From: Andrew Leon
Sent time: 07/01/2021 04:42:19 PM
To: Mercer Island ePermit Tech
Subject: FW: 2105-227 Planning Review Comments
Attachments: 4 NIEDERMAN_GARAGE-DRIVEWAY GATE.pdf

From: Andrew Leon <andrew.leon@mercerisland.gov>
Date: Friday, June 18, 2021 at 6:09 PM
To: Chris Niederman <Chris@niederman.com>
Cc: Mercer Island ePermit Tech <epermit.tech@mercergov.org>
Subject: 2015-227 Planning Review Comments

I have completed my first round of review of your building permit to install an automatic electric gate at 6800 96th Ave SE, as process under permit number 2105-227. I have the following review comments:

DRIVEWAY ELEVATION VIEW
SCALE 1/8" = 1'-0"

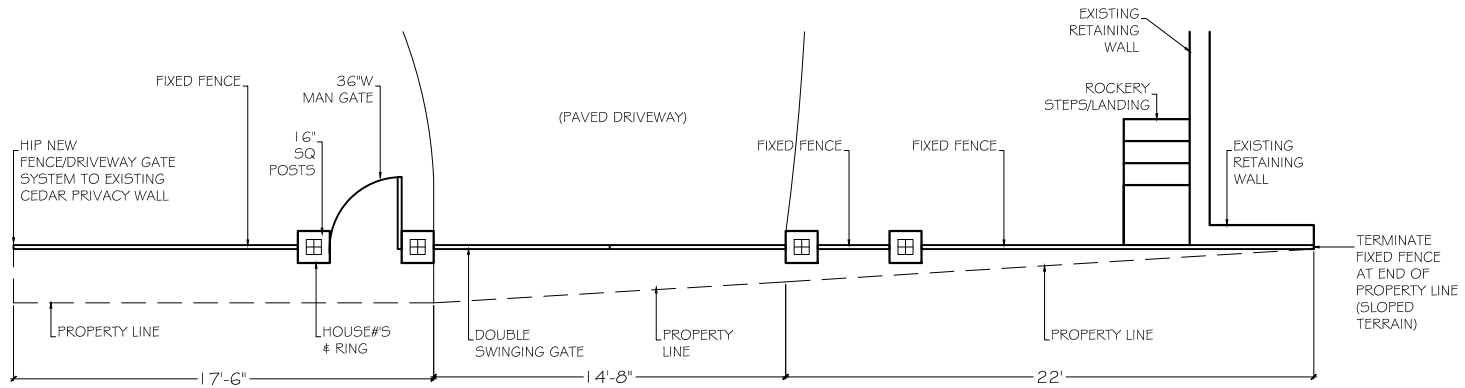
The plans show that the posts of the proposed gate and fence are to be 78 inches in height, with elements extending above 78 inches. This exceeds the 72 inch height limit. Please revise the height of the posts so they meet the height limit listed in [MICC 19.02.050\(E\)\(1\)\(a\)\(i\)](#).

I received this set of drawings from Mr. Niederman today. They address my comments, so I have changed my review line in Trakit from WCI to Approved. These revised drawings should be added to the approved plan set.

DRIVEWAY ELEVATION VIEW

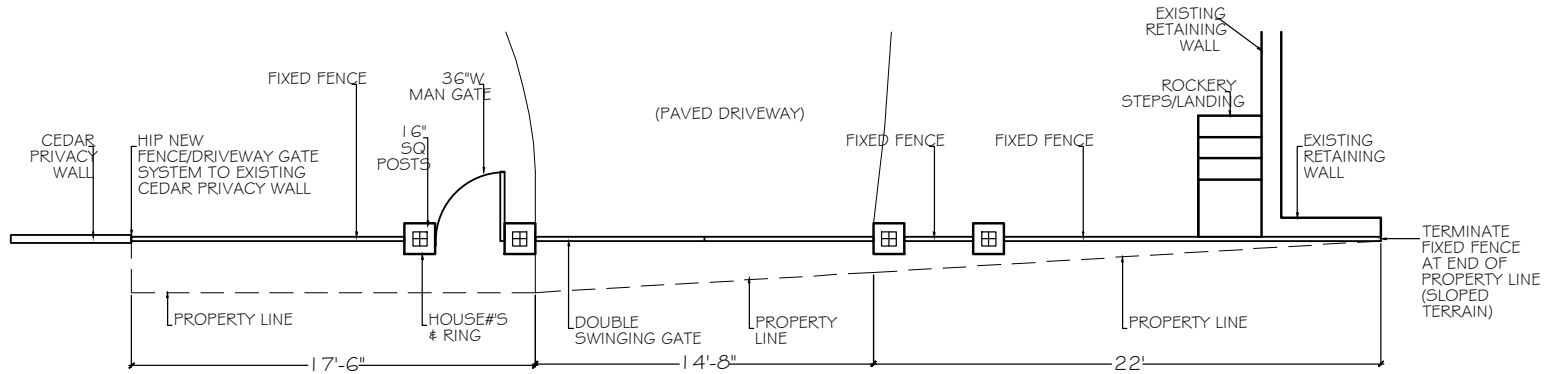
MIC 19.02.050(C)(1) states that the height of a fence is measured from the top of the fence, including posts, to the existing grade or finished grade, whichever is lower, directly below the section of the fence being measured. The lights are part of the posts, so they would also need to meet the 72-inch height limit for the fence.

- [MICC 19.02.050\(E\)\(1\)\(a\)\(i\)](#) states that fences and gates are allowed to a maximum height of 72 inches within required side yards. Further, [MICC 19.02.050\(C\)\(1\)](#) states that the height of a fence or gate is measured from the top of the fence or gate, including posts, to the existing or finished grade, whichever is lower, directly below the section of the fence or gate being measured.
